Principal Areas of Disagreement Summary Statement (PADSS)

Version Number: 2

Submitted at: Deadline 2: 26 March 2024

This statement has been prepared by Horsham District Council (“the Council”) with input from the joint local authorities, technical consultants and legal specialists. The Northern Runway Project application was submitted to the Planning Inspectorate on 6 July 2023 and accepted for Examination on 3 August 2023. The Council is one of the local authorities identified by Section 43(2) of the Planning Act 2008 and in response to the Examining Authority’s (“ExA”) Procedural Decision letter of 8 September 2023 to the Applicant and the Host and Neighbouring Authorities, the Council has prepared this Principal Areas of Disagreement Summary Statement (“PADSS”) (Version 2). This Statement identifies the principal areas of disagreement and is considered to be a live document.

Diagram 3.3.9: Model performance before and after adjustment, London zone

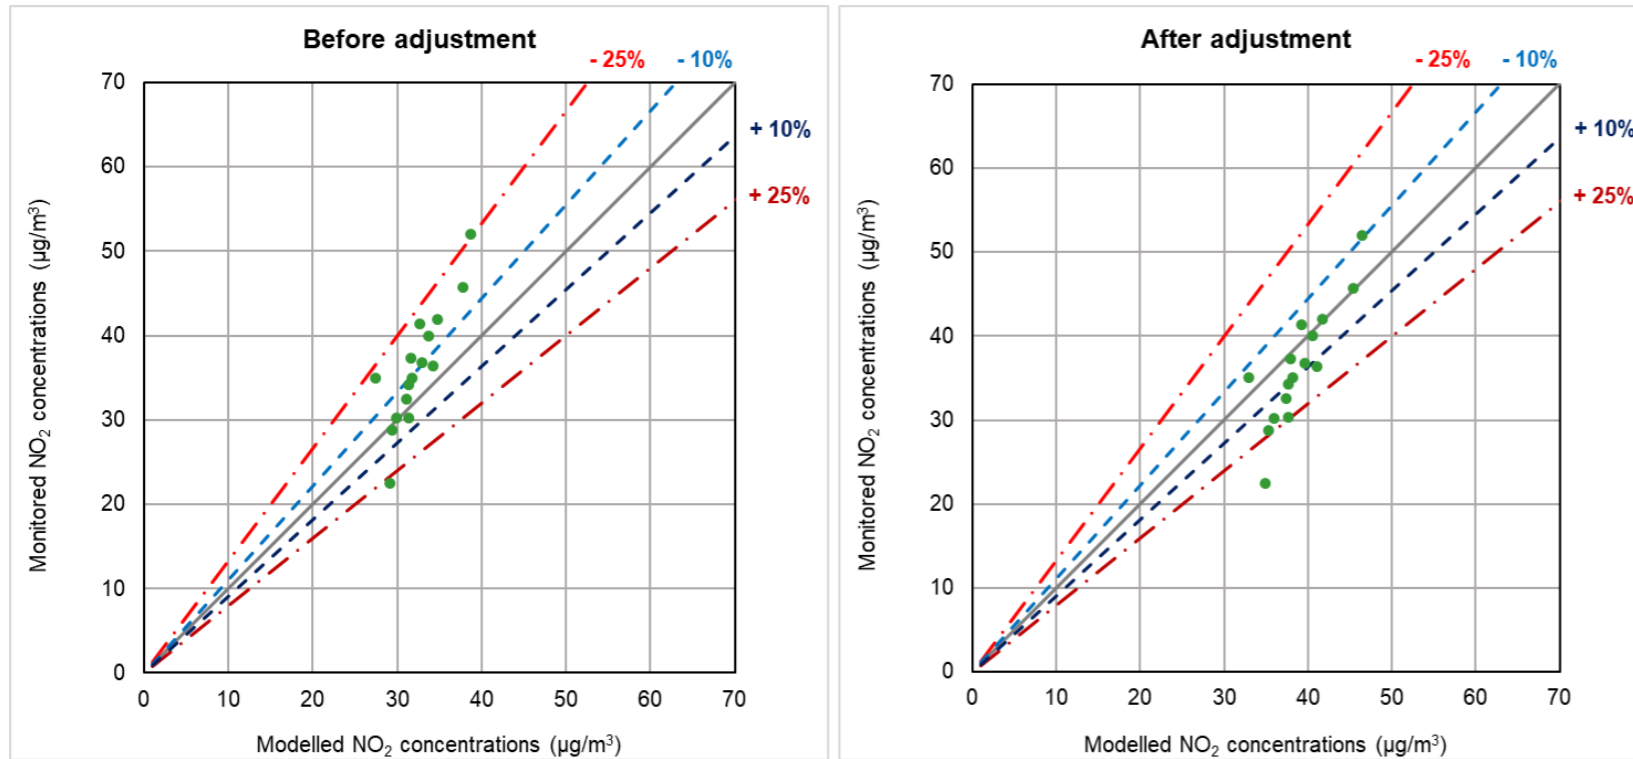
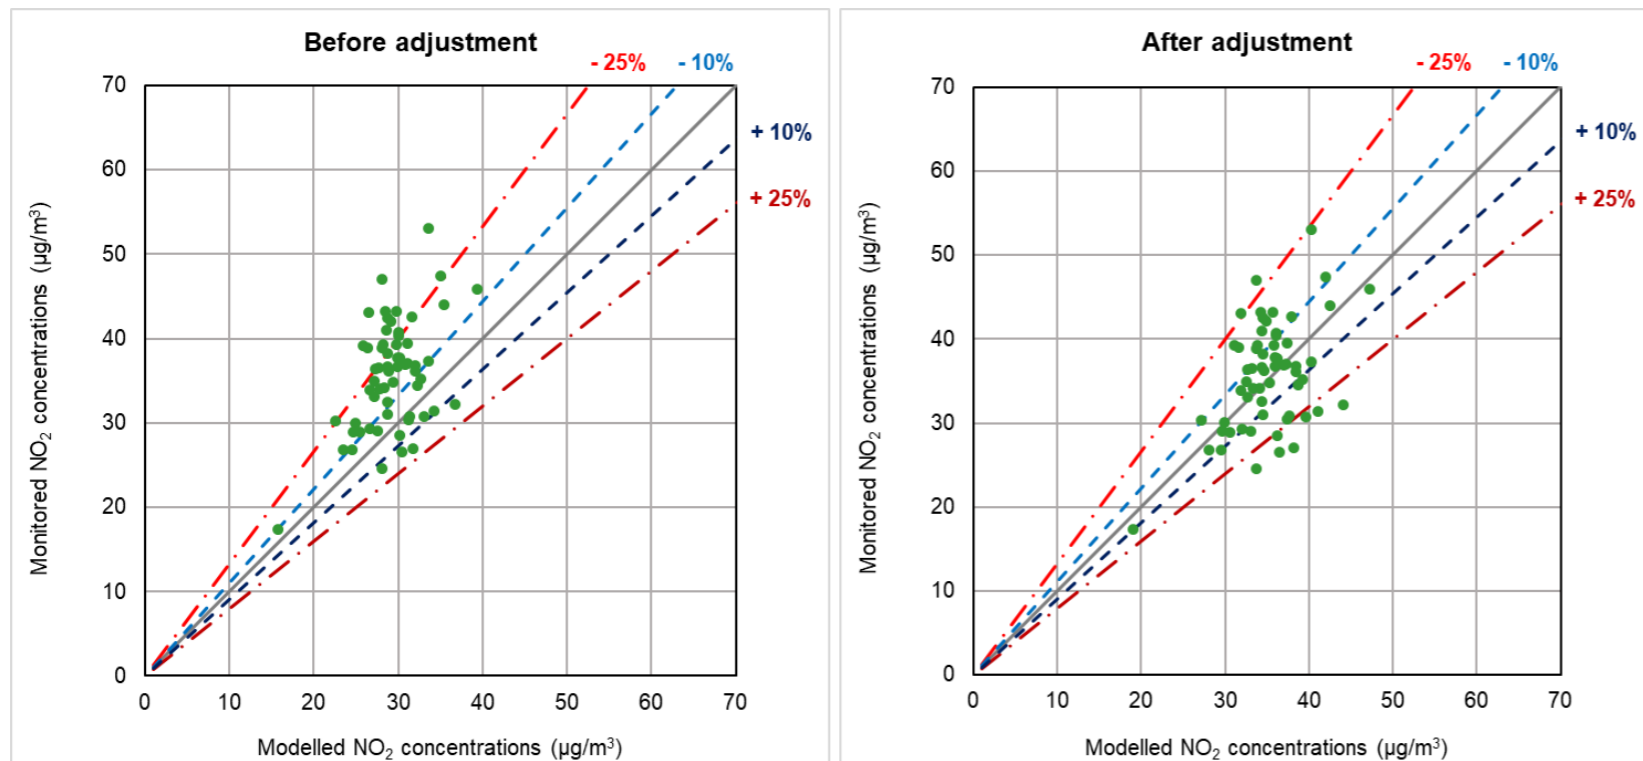
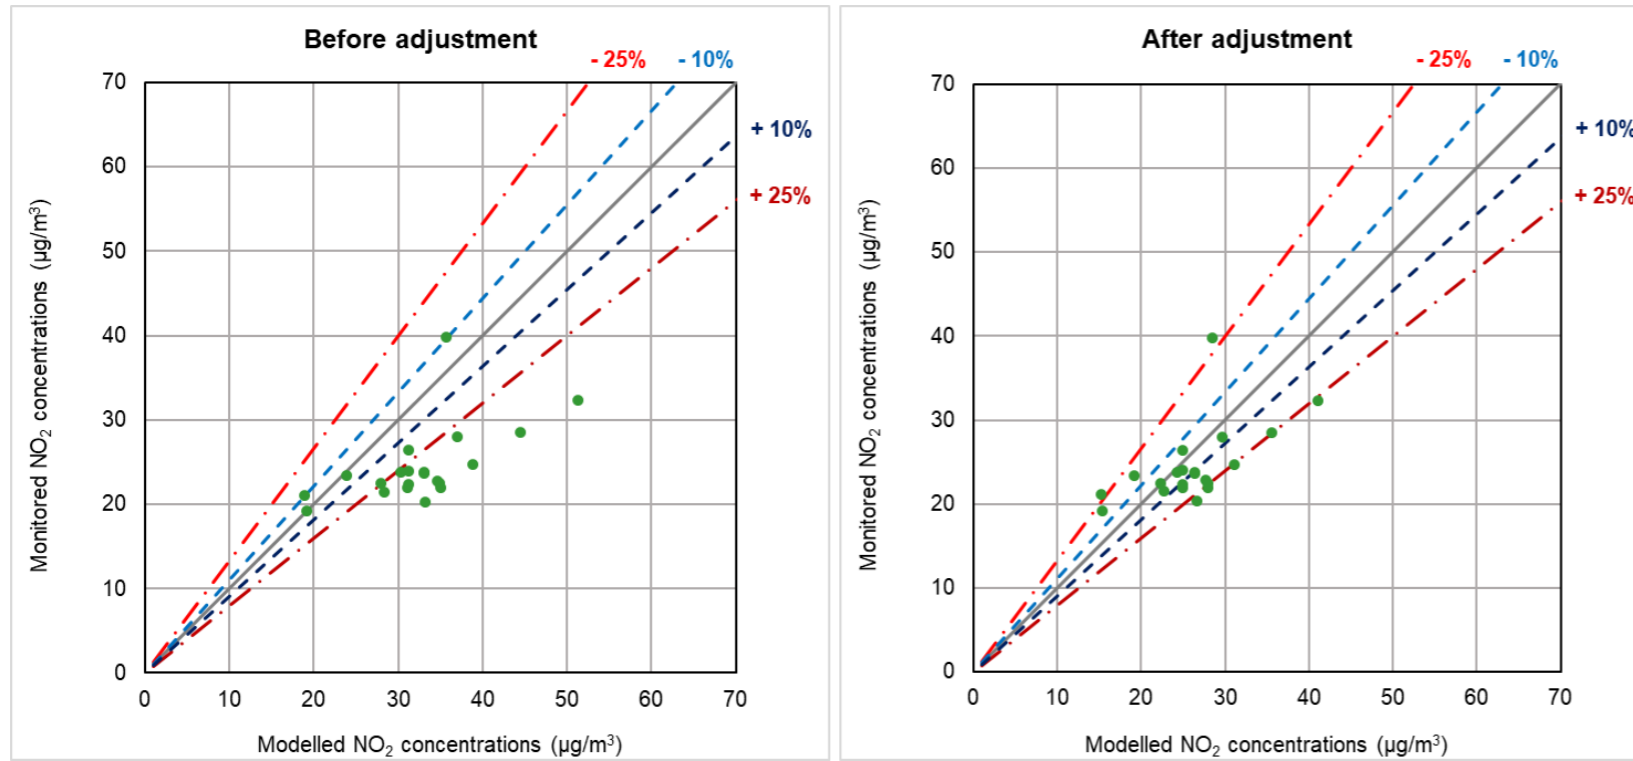
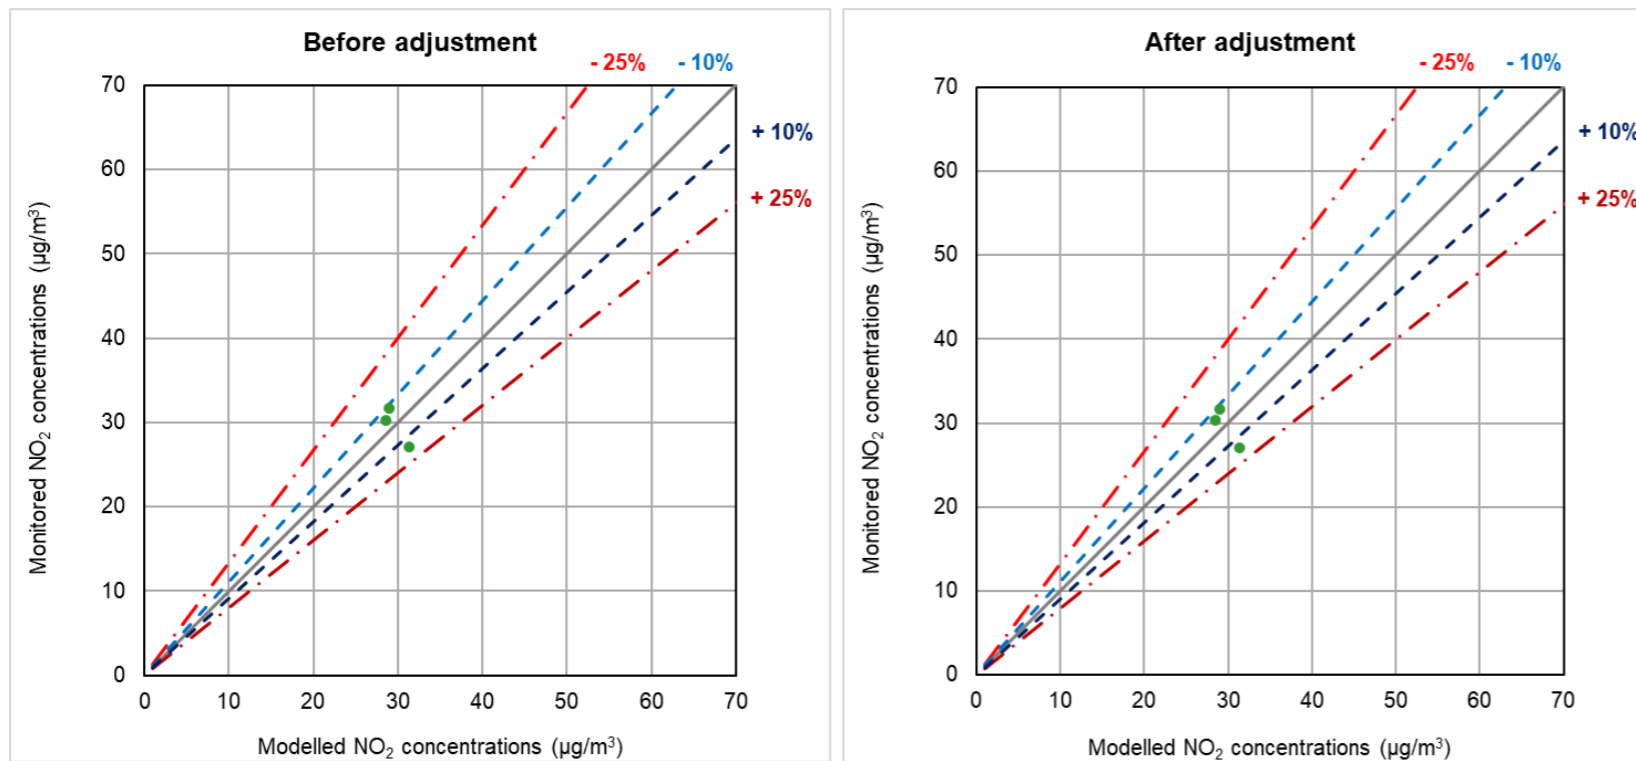
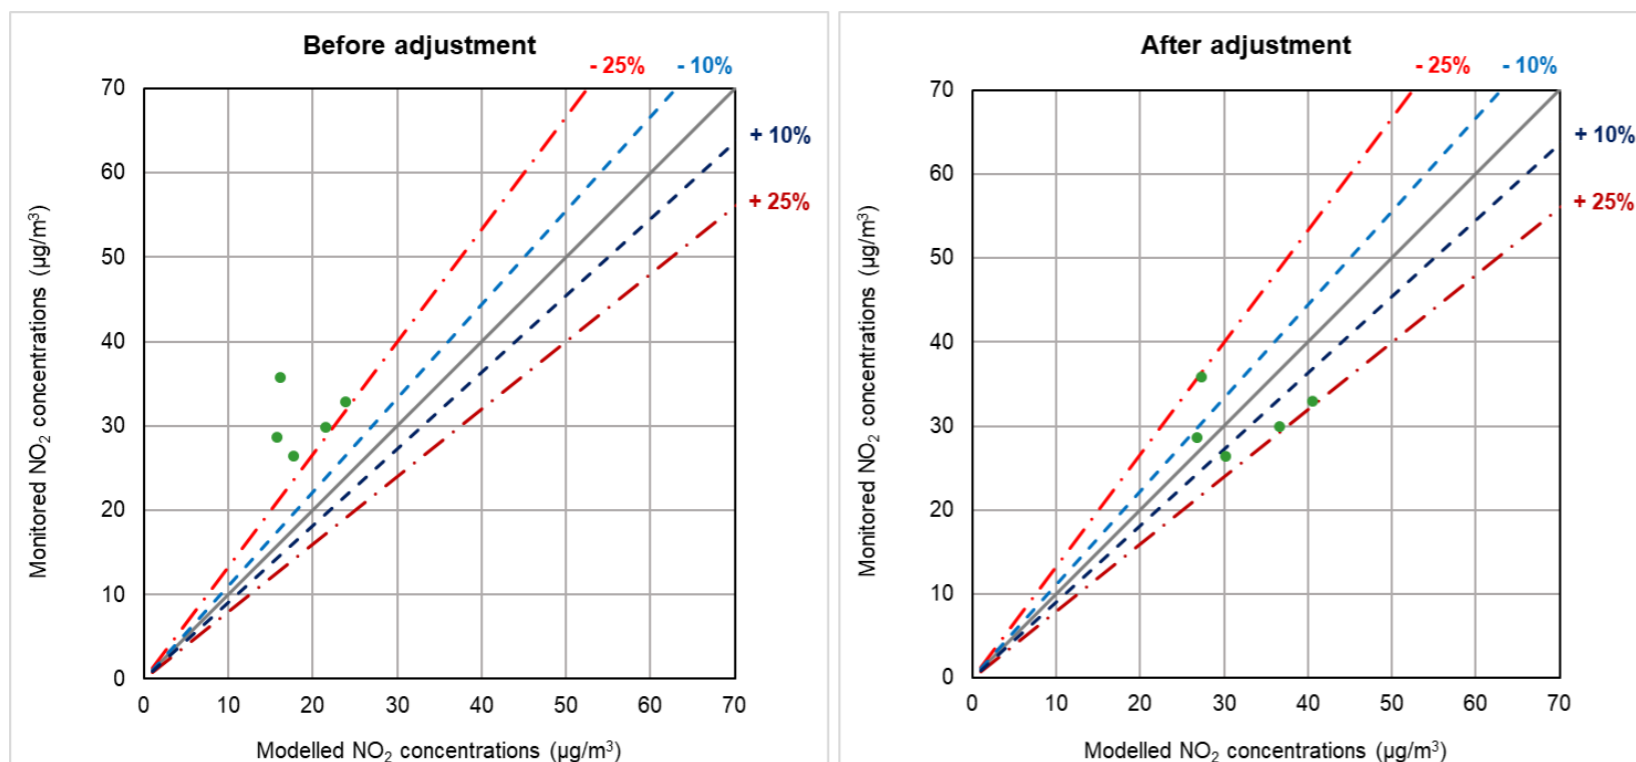
3.5	Model Set Up and Methodology	Regarding model verification, Appendix 13.6.1: Air Quality Data and Model verification is missing details on how model verification factors for the selected zones were established. Details are required of the initial	The Applicant should provide further details in relation to the model verification	Uncertain

HDC Ref.	Principal Issue in Question	Concern held	What needs to change / be amended / be included in order to satisfactorily address the concern?	Likelihood of concern being addressed during Examination
		<p>verification including Monitored Road NOx Contribution versus Unverified Modelled Road NOx, which monitoring sites were used, and which were removed from the verification process.</p> <p>To facilitate the scrutiny of the model set up and any assumptions used, it is requested that a complete set of input files be shared for 2018 (Base Year) and 2029 (nearest future year). In addition, Operational and Construction impacts for 2029 should be modelled jointly as one scenario, in order to enable the evaluation of all impacts associated with the development.</p>
